16EPC-40081 Amended Site Development Plan for Subdivision

**II. ADDITIONAL CONDITIONS OF APPROVAL –
16EPC-40080 – APRIL 13, 2017 – SITE DEVELOPMENT
PLAN FOR BUILDING PERMIT**

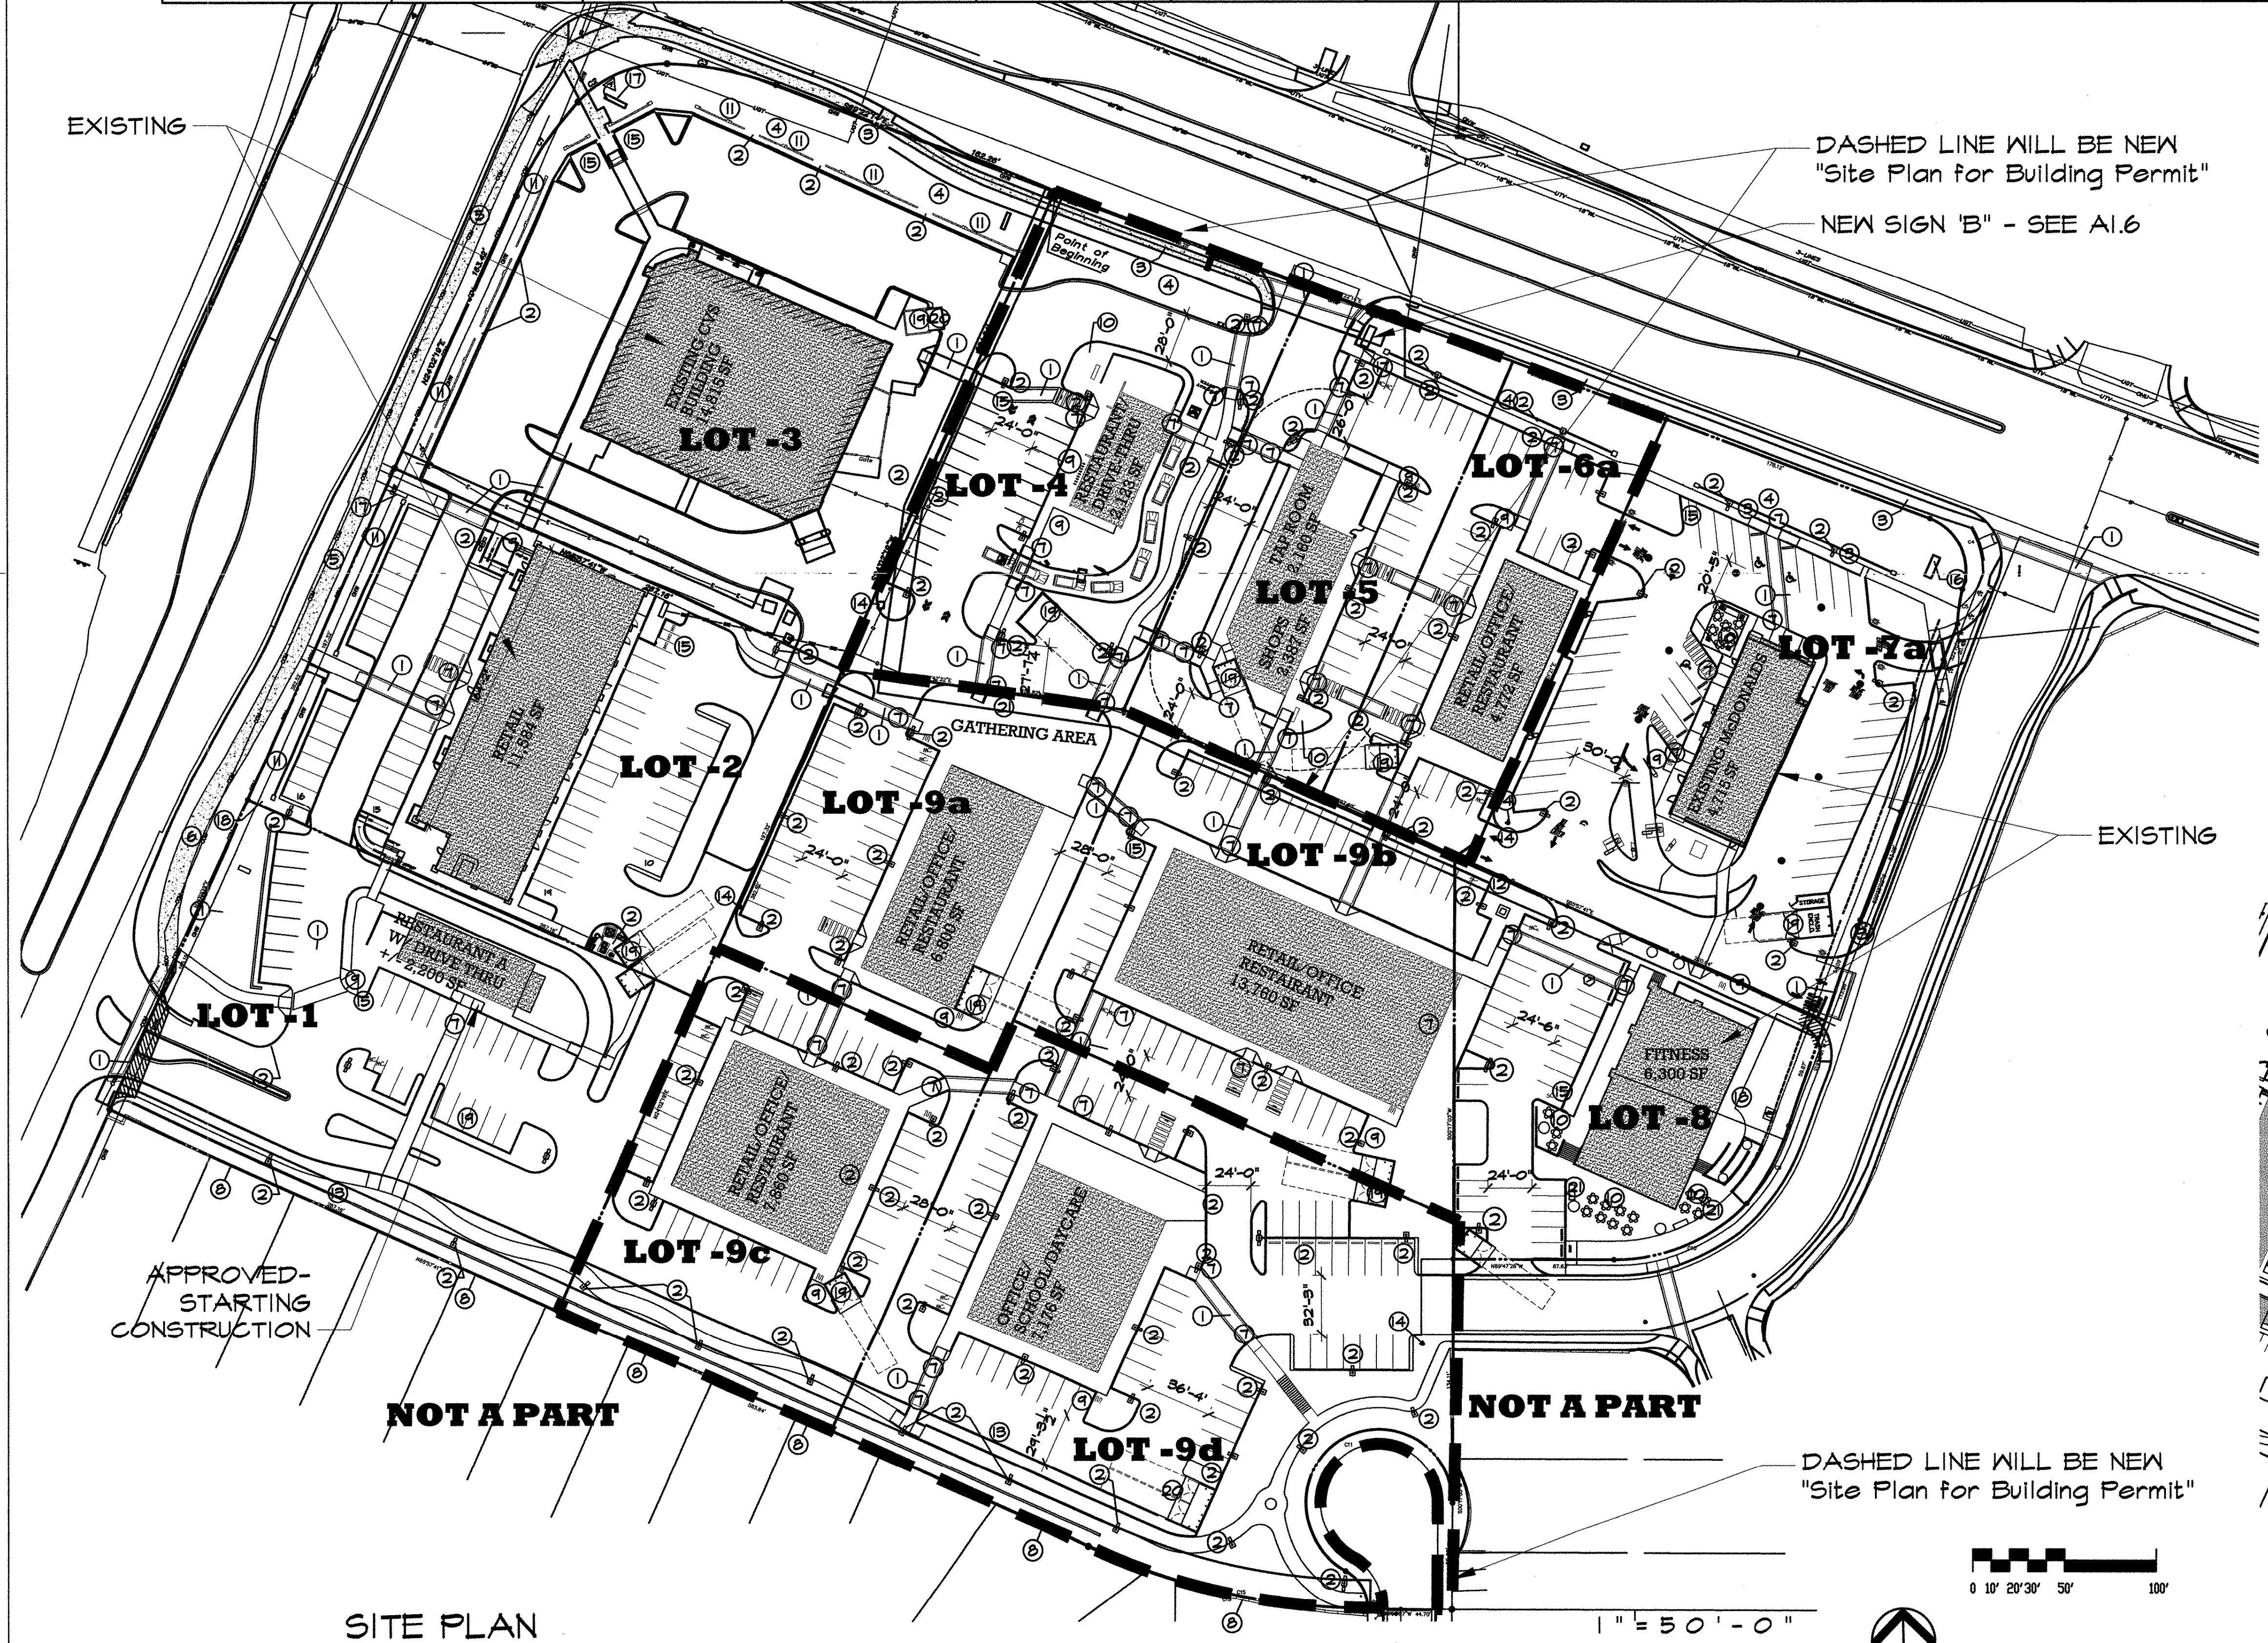
- This submittal for Building Permit applies to Lots 4, 5, 6a (no bldg. at this time) and Lots 9c & 9d (no bldgs. at this time).
- Please list the width and length for all existing and proposed parking spaces. Some dimensions are not shown.

- Added note: "The ADA access aisles shall have the words "NO PARKING" in capital letters, each of which shall be at least one foot high and at least two inches wide, placed at the rear of the parking space so as to be close to where an adjacent vehicle's rear tire would be placed. (66-1-4.1.B NMSA 1978)" to Sheet A1.5

- See Sheets A1.2 and A1.3 for location of handicap signs on site plans.
- See Sheets A1.2 and A1.3 for drive aisle widths and radii.
- See Sheets A1.2, A1.3 and A1.4 for radii for curves shown; for passenger vehicles, the minimum end island radius for passenger vehicles is 15 ft. Radius for delivery trucks, fire trucks, etc. is 25 ft. or larger.

- At the drive through facility on Lot 4, a 25 foot minimum radius (inside edge) for all turns in the drive aisle has been added with a minimum drive through lane width of 12 feet.

- Have added pavement directional signage and a posted “Do Not Enter” sign at the point of egress. Detail and location of posted signs shown on Sheet A1.2.
- Parking spaces have been relocated so as not to cross over lot lines.
- Pedestrian path’s widths on site and at building frontages have been added.
- A landing after the handicap ramps to access the buildings has been added. (Handicap stalls have been reduced 18 feet in length.)
